Your ref: SSD 9368
File no: MC-19-00004

Re: SSD9368 - Farmland Drive SCHOFIELDS – Alex Avenue Public School

ATTACHMENT A

SITE LAYOUT

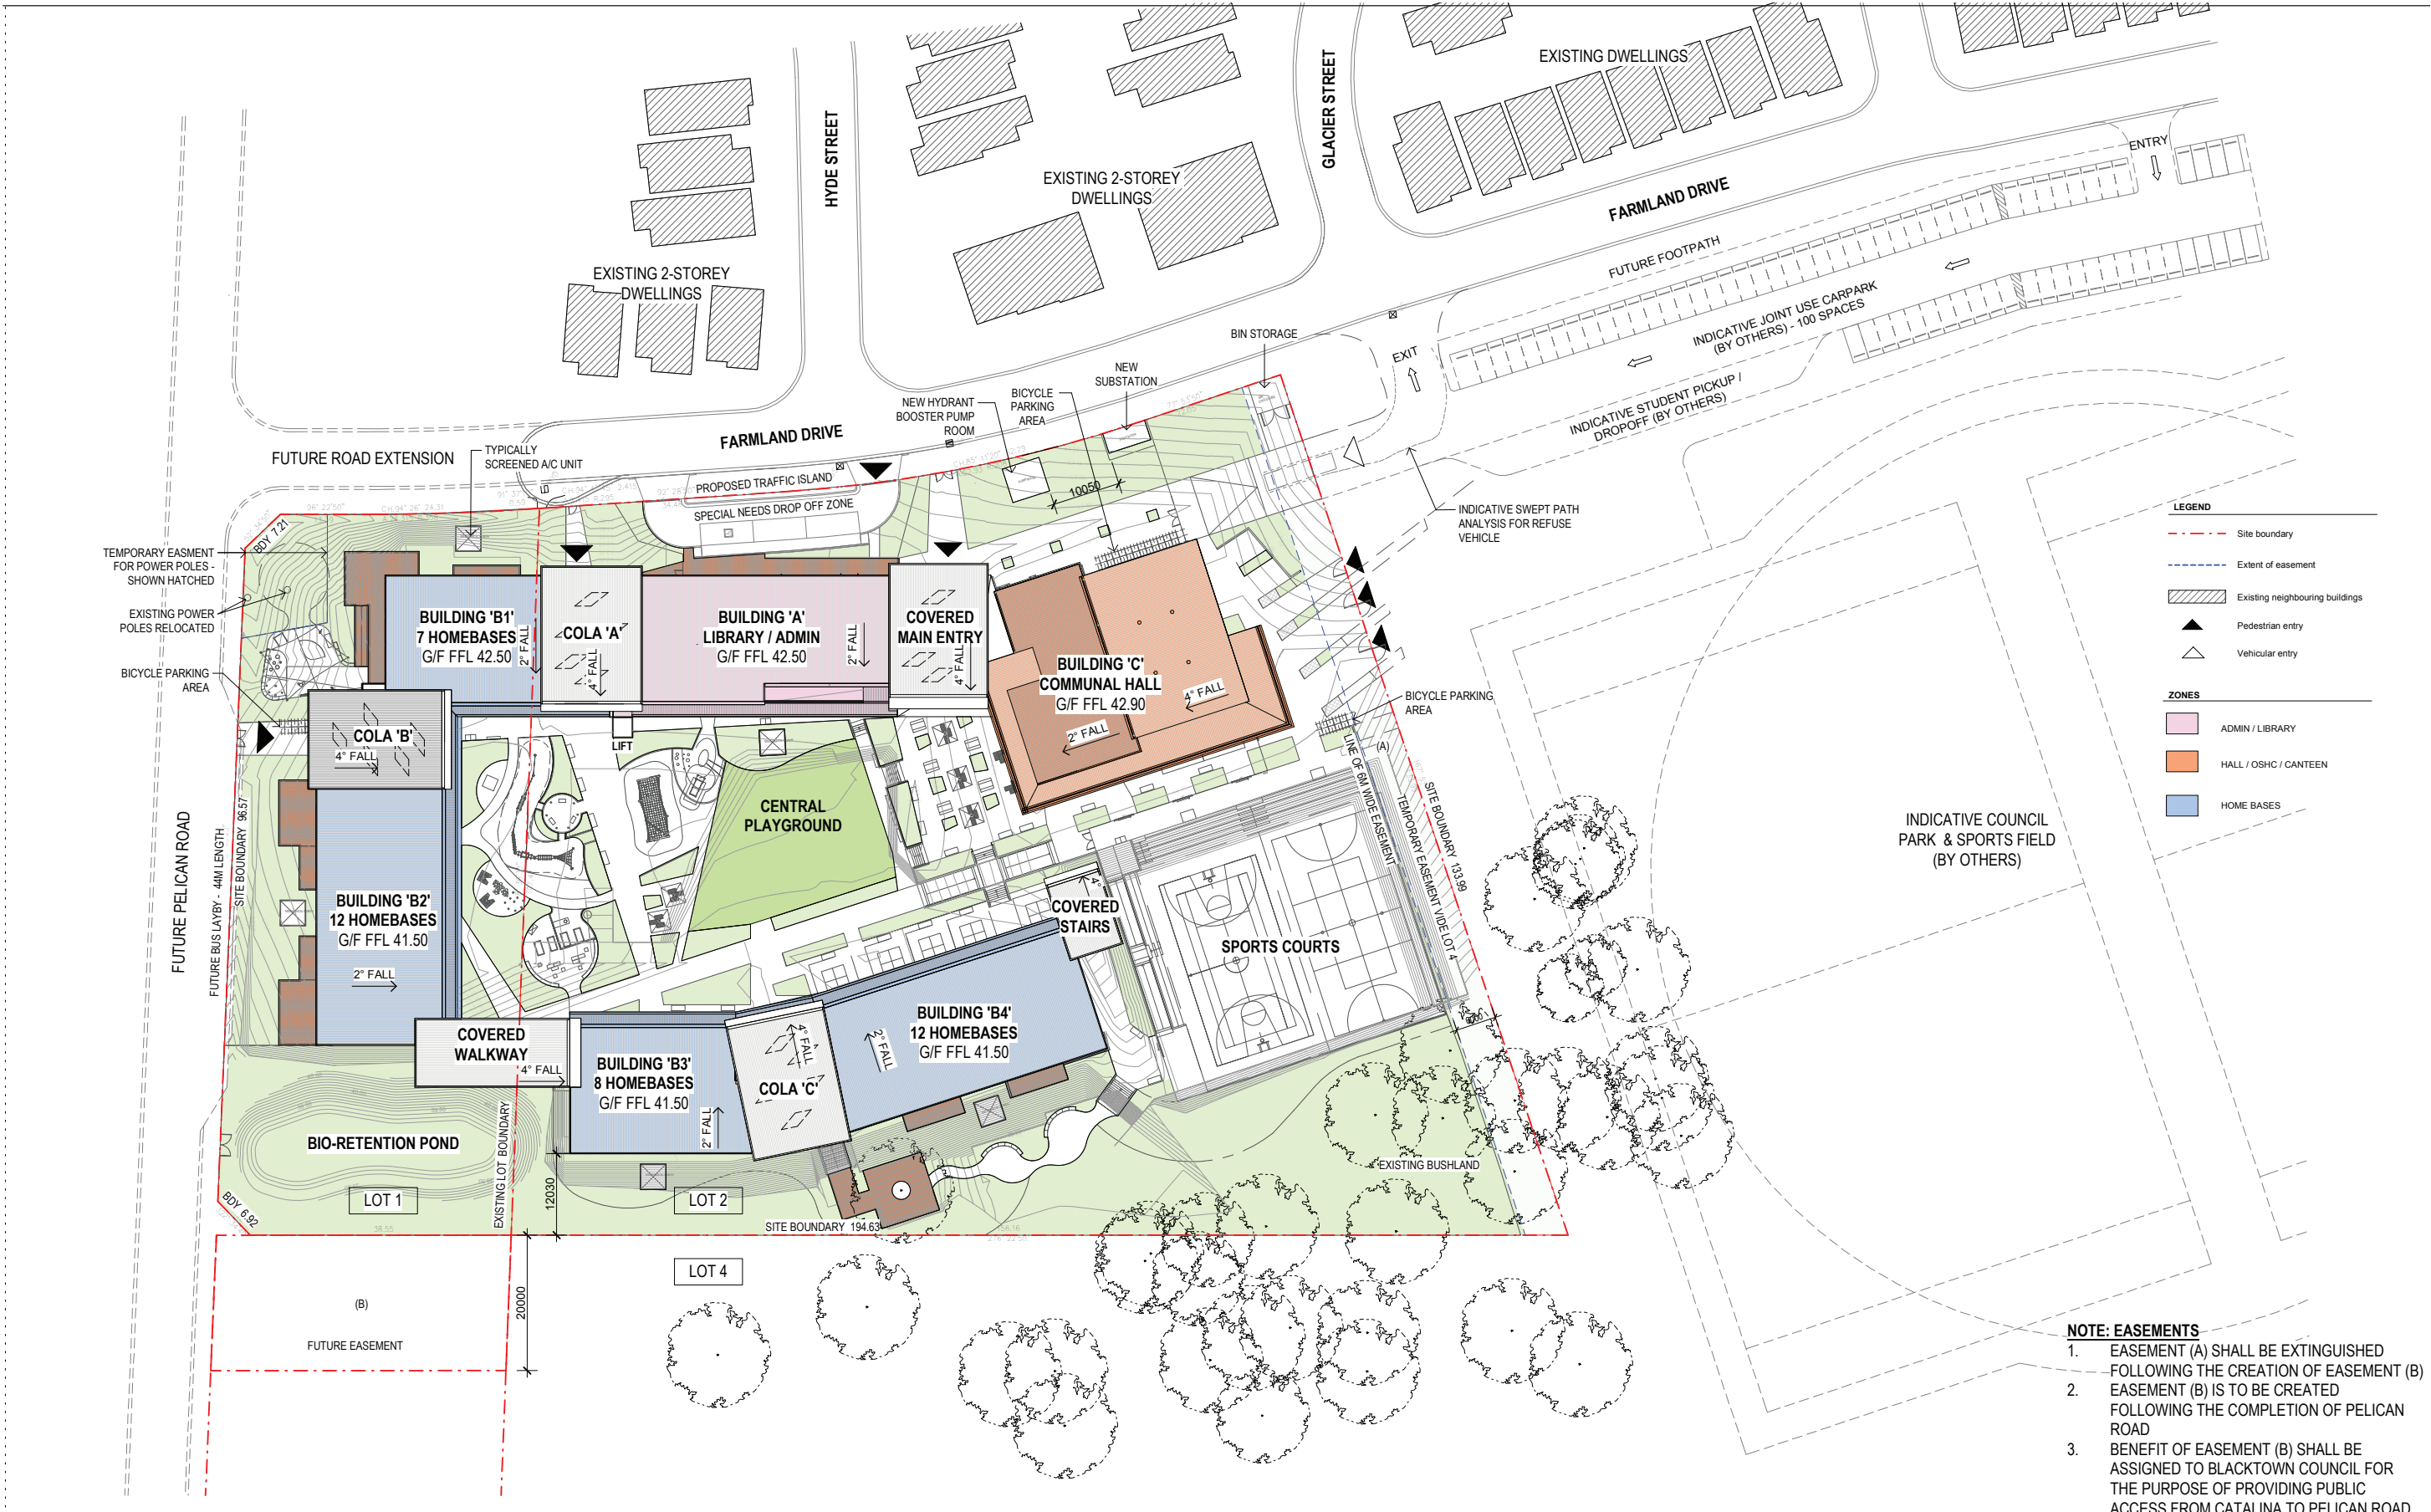
1. The architectural plans do not include a detailed site plan clearly identifying the boundaries of the site, adjoining properties, proposed buildings, number of parking spaces on school site and on our land clearly indicating and nominating accessible parking spaces, access parking, bin enclosure, garbage truck access to and from the site, garbage truck swept path and turning circle.
2. The architectural plans do not provide sufficient information and labelling to enable assessment of the proposal.

**SITEWORKS AND STORMWATER
MANAGEMENT PLAN - SHEET 02**

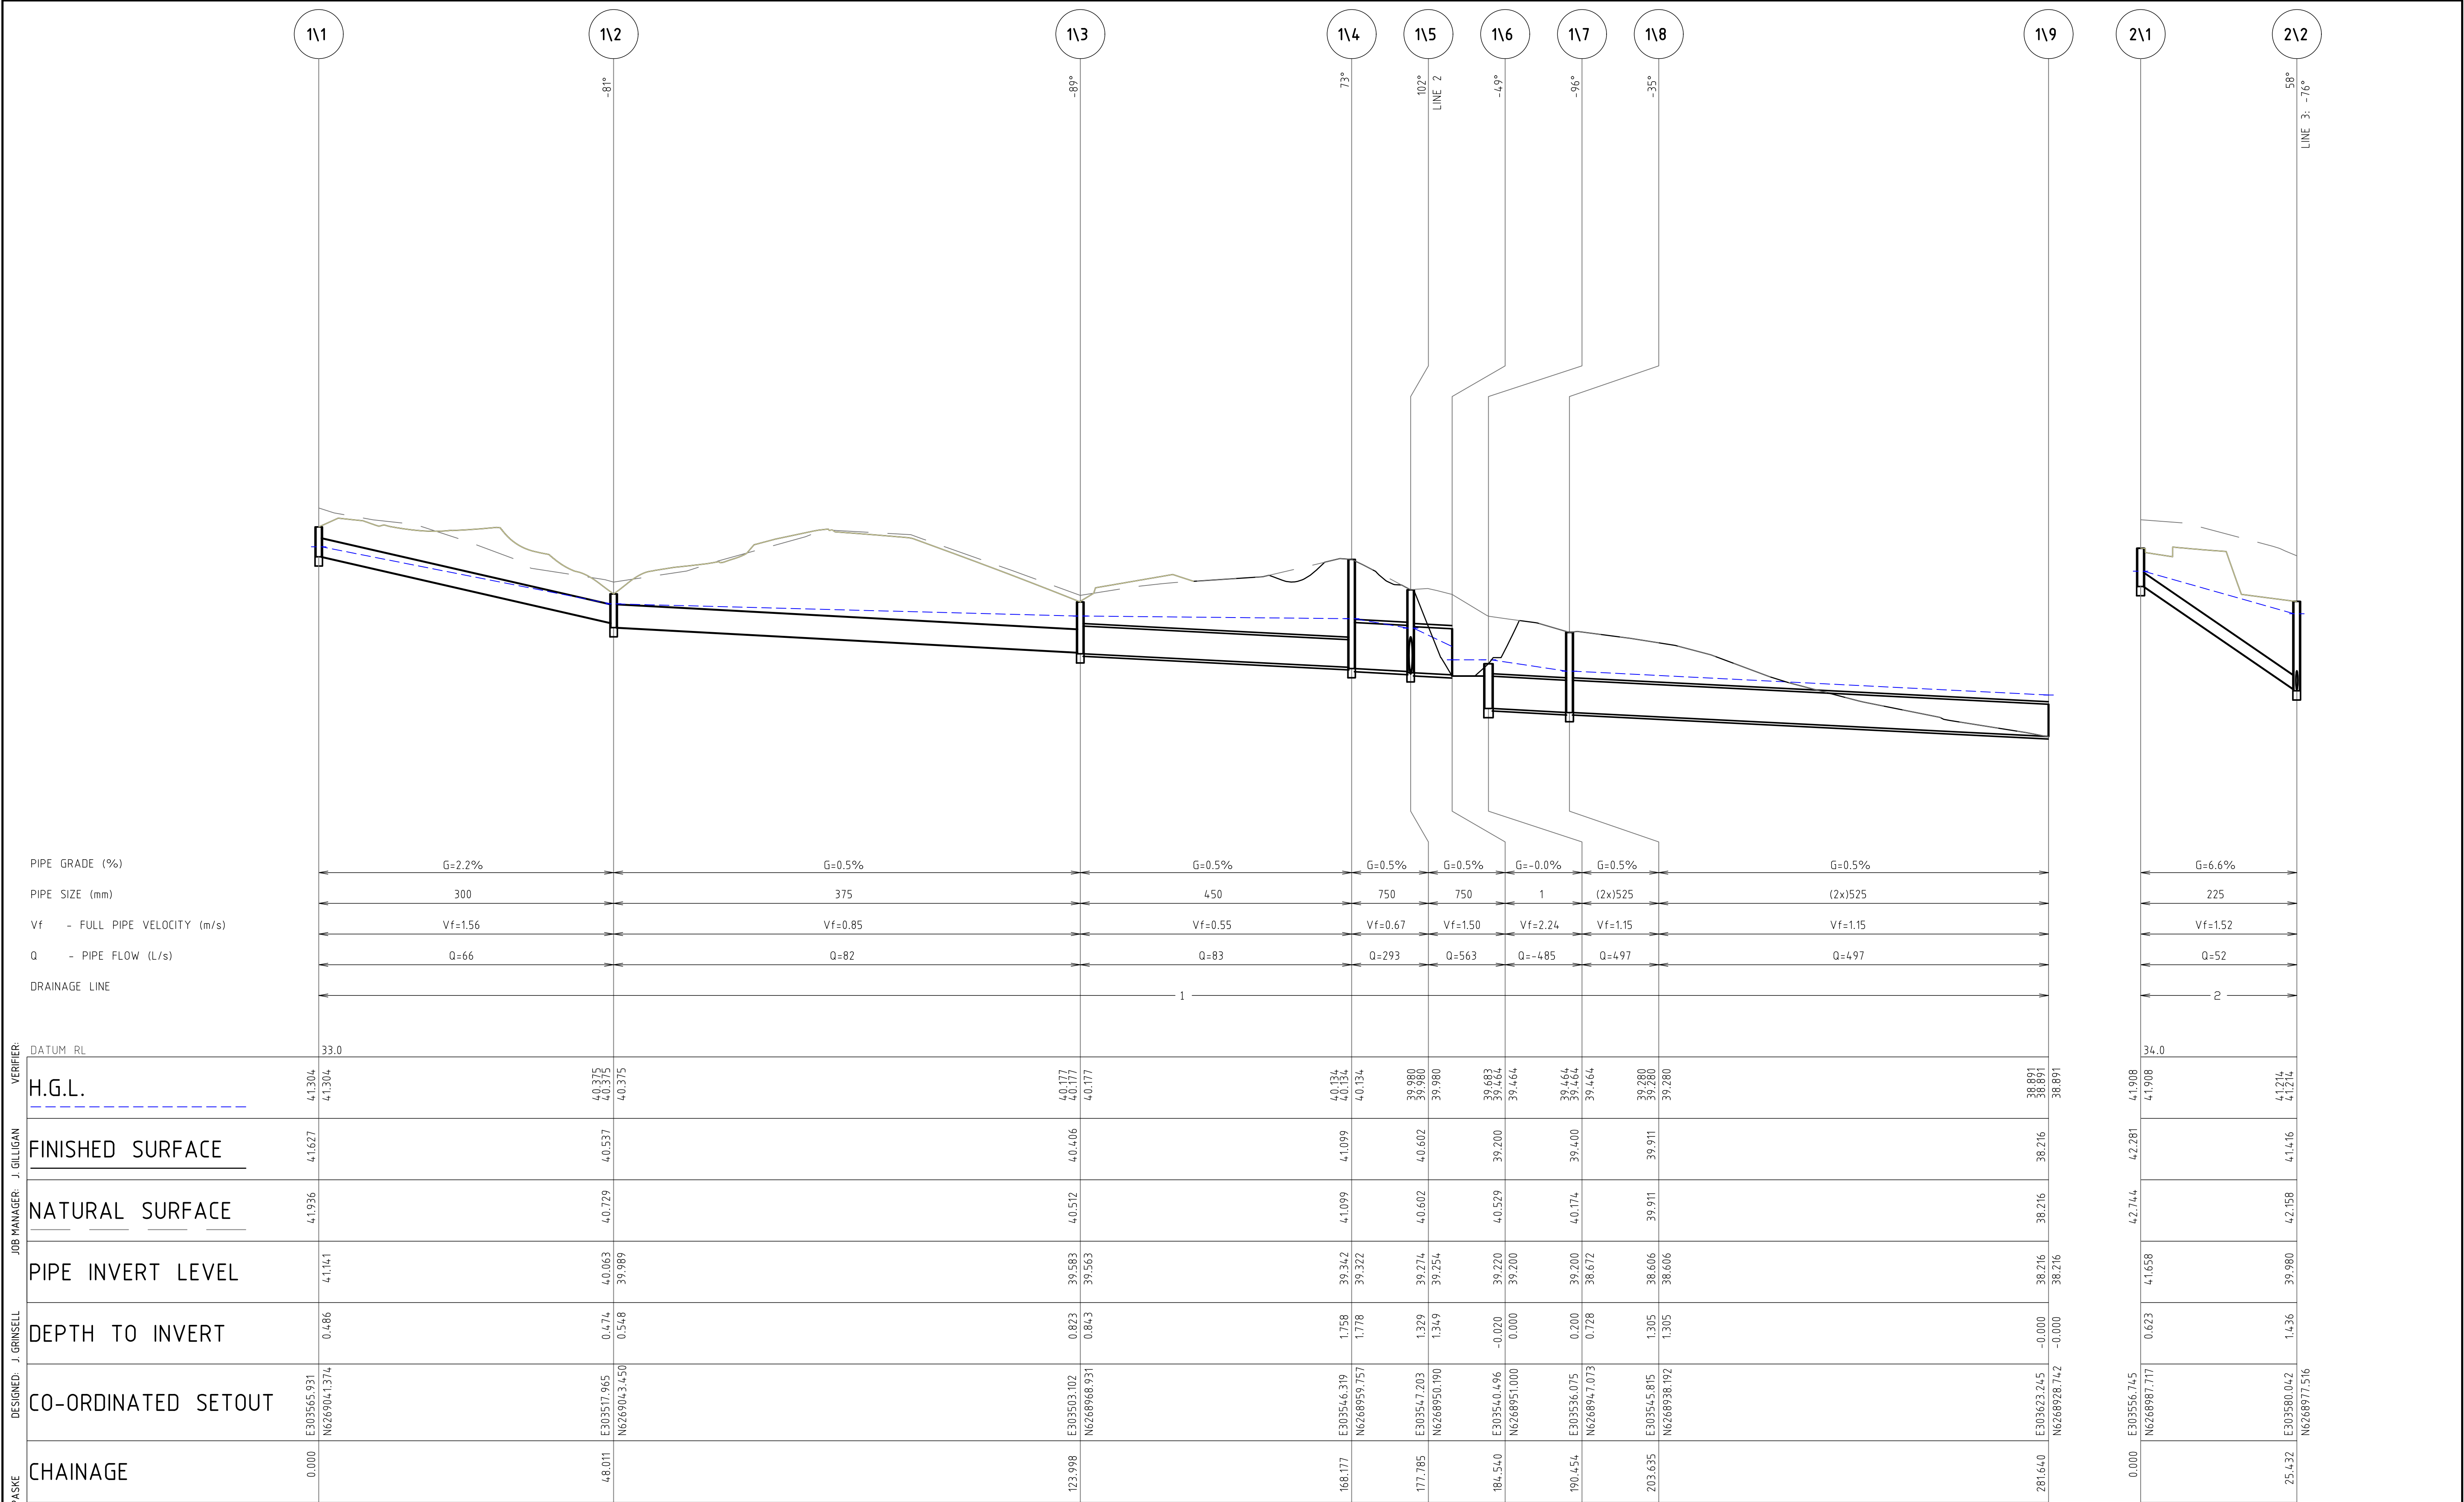
8. Permanent onsite stormwater detention is required to treat the development site as per BCC GC DCP and in accordance with Councils Standard Drawings A(BS)175M. The applicant may request Council to consider this requirement be addressed via an offsite detention system as part of a Voluntary Planning Agreement where contributions should be made to Council, however this will be subject to agreement

from Councils Asset Design Services Team. If the applicant is granted approval for an offsite treatment of this requirement (VPA) then until such time that the downstream regional infrastructure is in place temporary on site detention system will be required in accordance with Councils Standard Drawings A(BS)175M and BCC GC DCP.

10. Permanent onsite stormwater quality treatment measures are required as per Councils DCP Part J.
11. All roads fronting the proposed site shall be constructed in accordance with BCC GC DCP Road Hierarchy (Alex Ave Precinct) and Engineering Guide for Development. This includes the extension of Farmland Drive to the west end of existing Farmland Drive and New road toward the north western frontage of site.

12. Permanent Water conservation requirements must be met under Councils DCP Part J.
13. The proposed concept discharge point is not supported. The proposed development shall discharge stormwater into Councils existing stormwater system. Note the proposed development shall ensure the internal stormwater configuration can facilitate a legal point of discharge and demonstrate that the ultimate configuration shall make smooth connection with future roads to be constructed toward the south western area of site.
